MONUMENT STEEL STRUCTURES

SITE AND UTILITY PLAN

18910 BASE CAMP ROAD
MONUMENT, COLORADO

Site Plan_v2-redline.pdf Markup Summary

SITE DEVELOPMENT PLAN
MONUMENT STEEL STRUCTURES
 SITE AND UTILITY PLAN
 18910 BASE CAMP ROAD
 MONUMENT, COLORADO

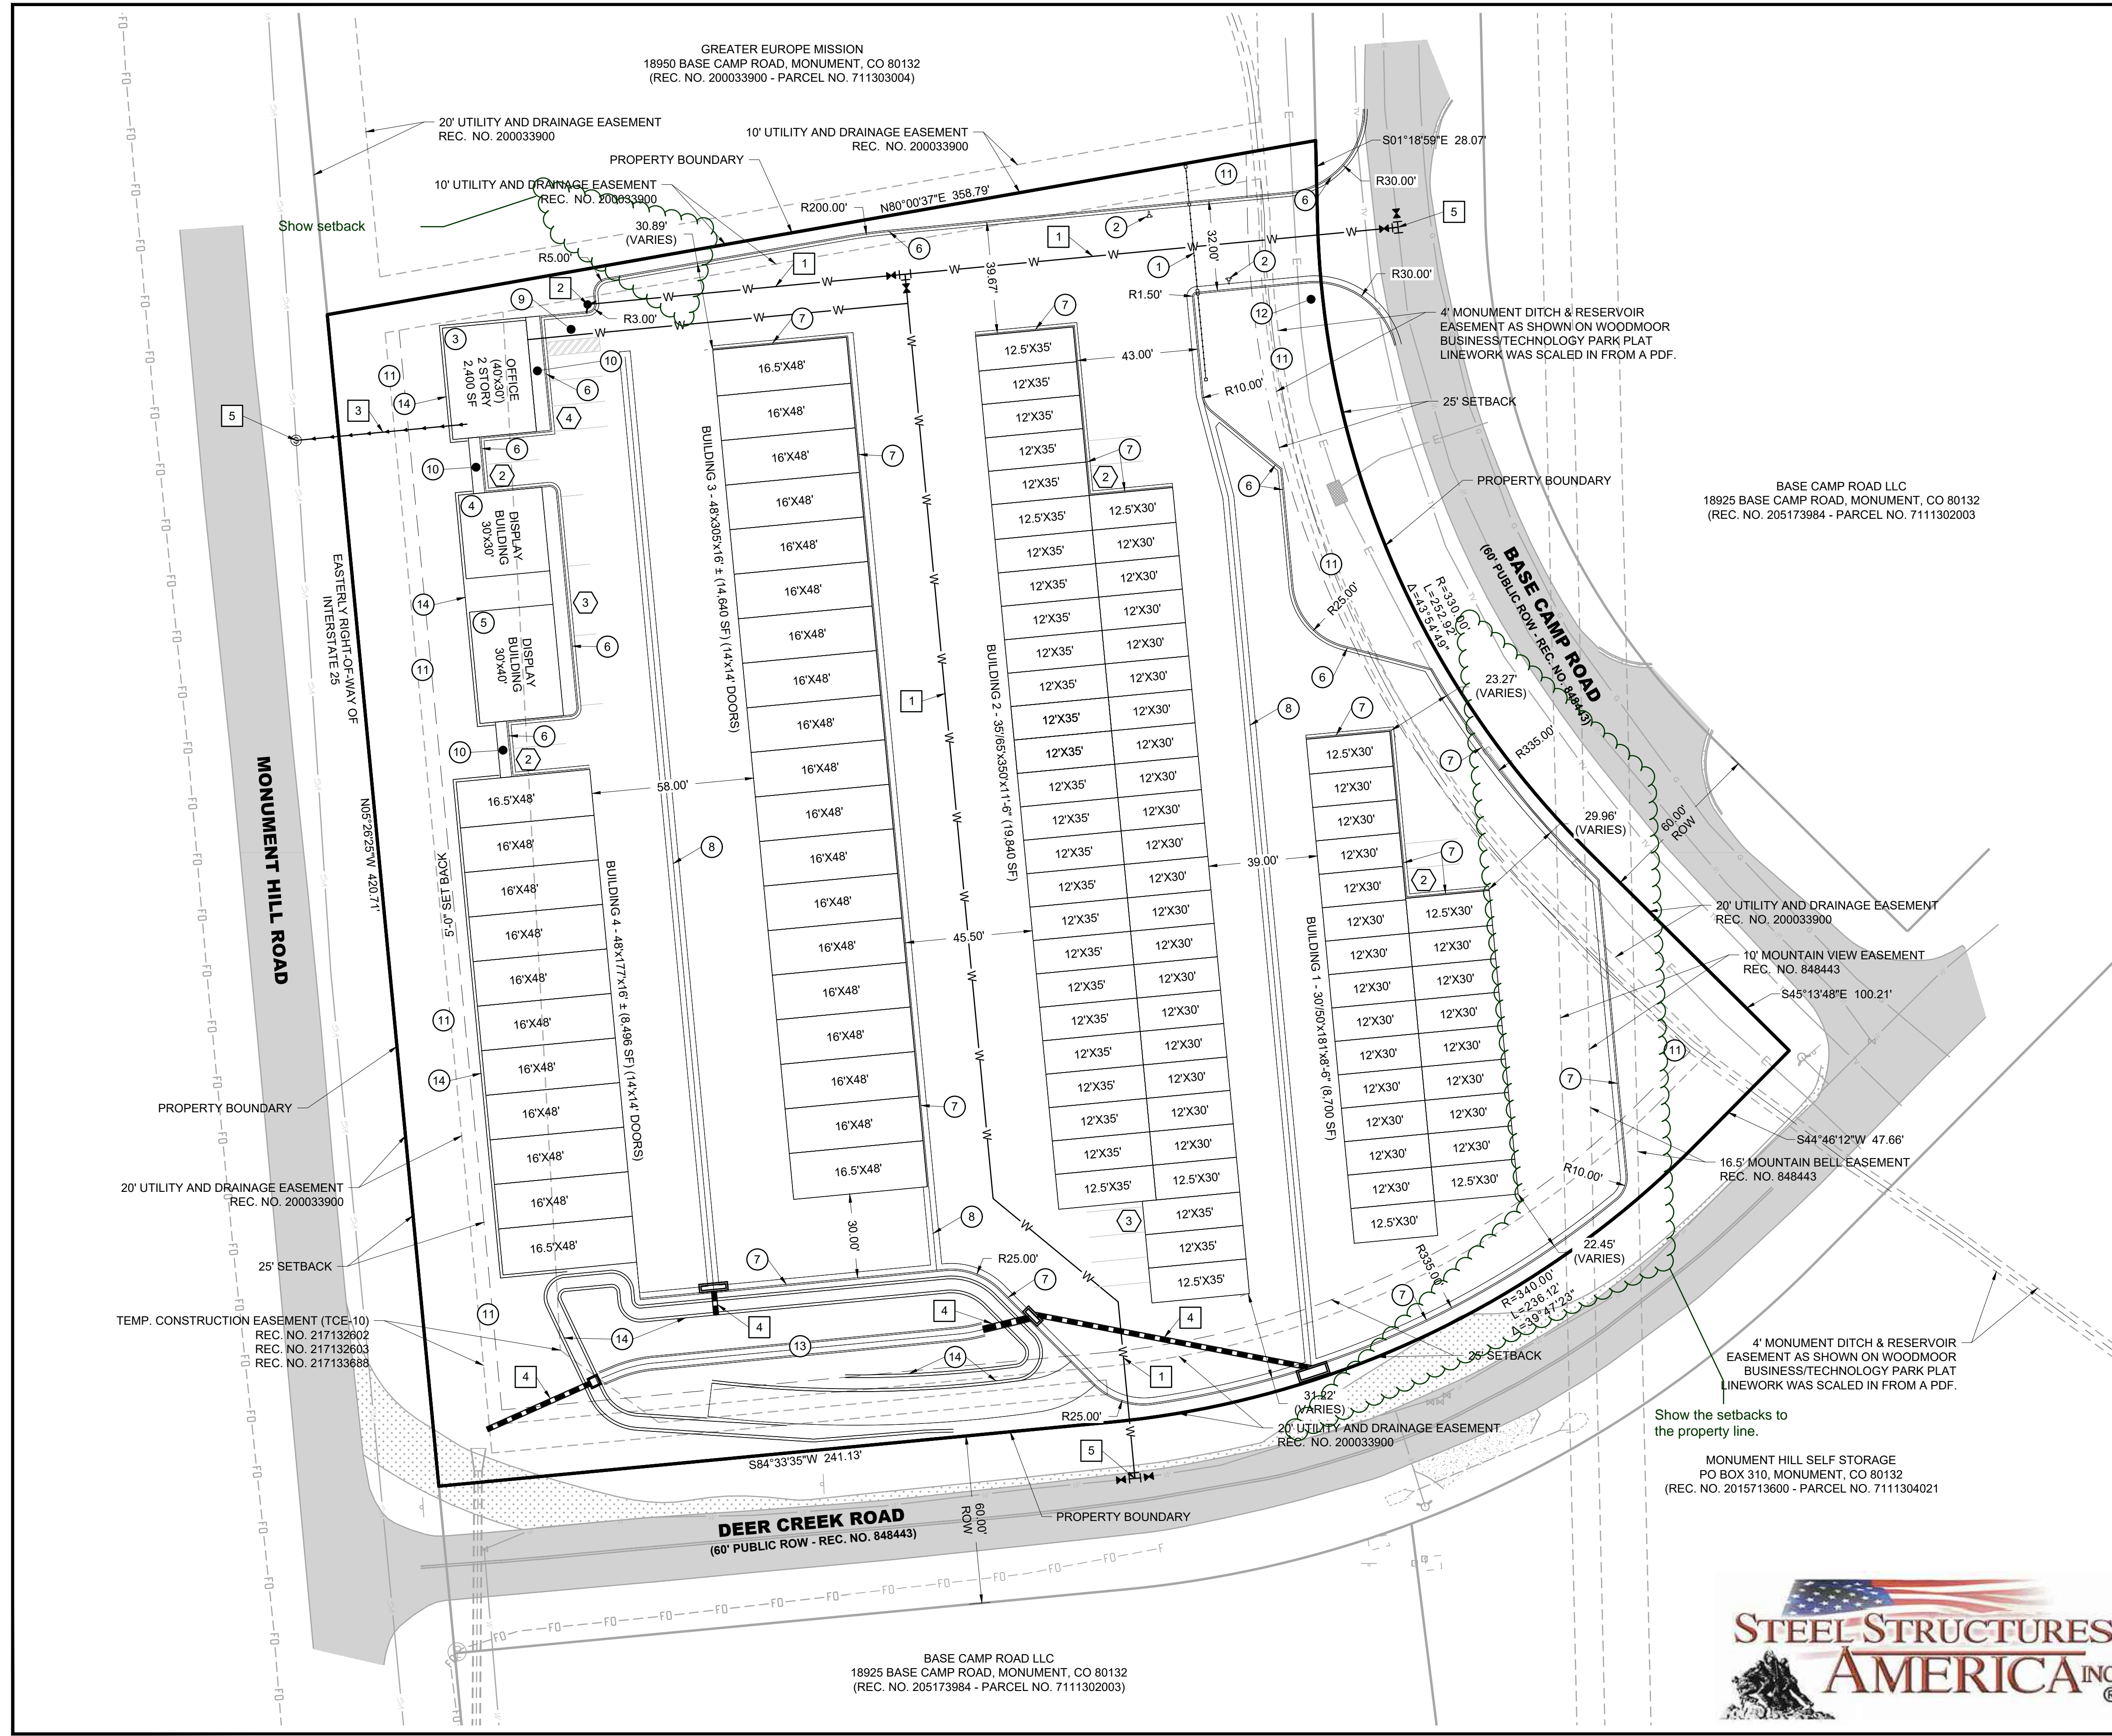
The siting of the storage buildings will be set at the site development plan phase. The setback cannot be varied.
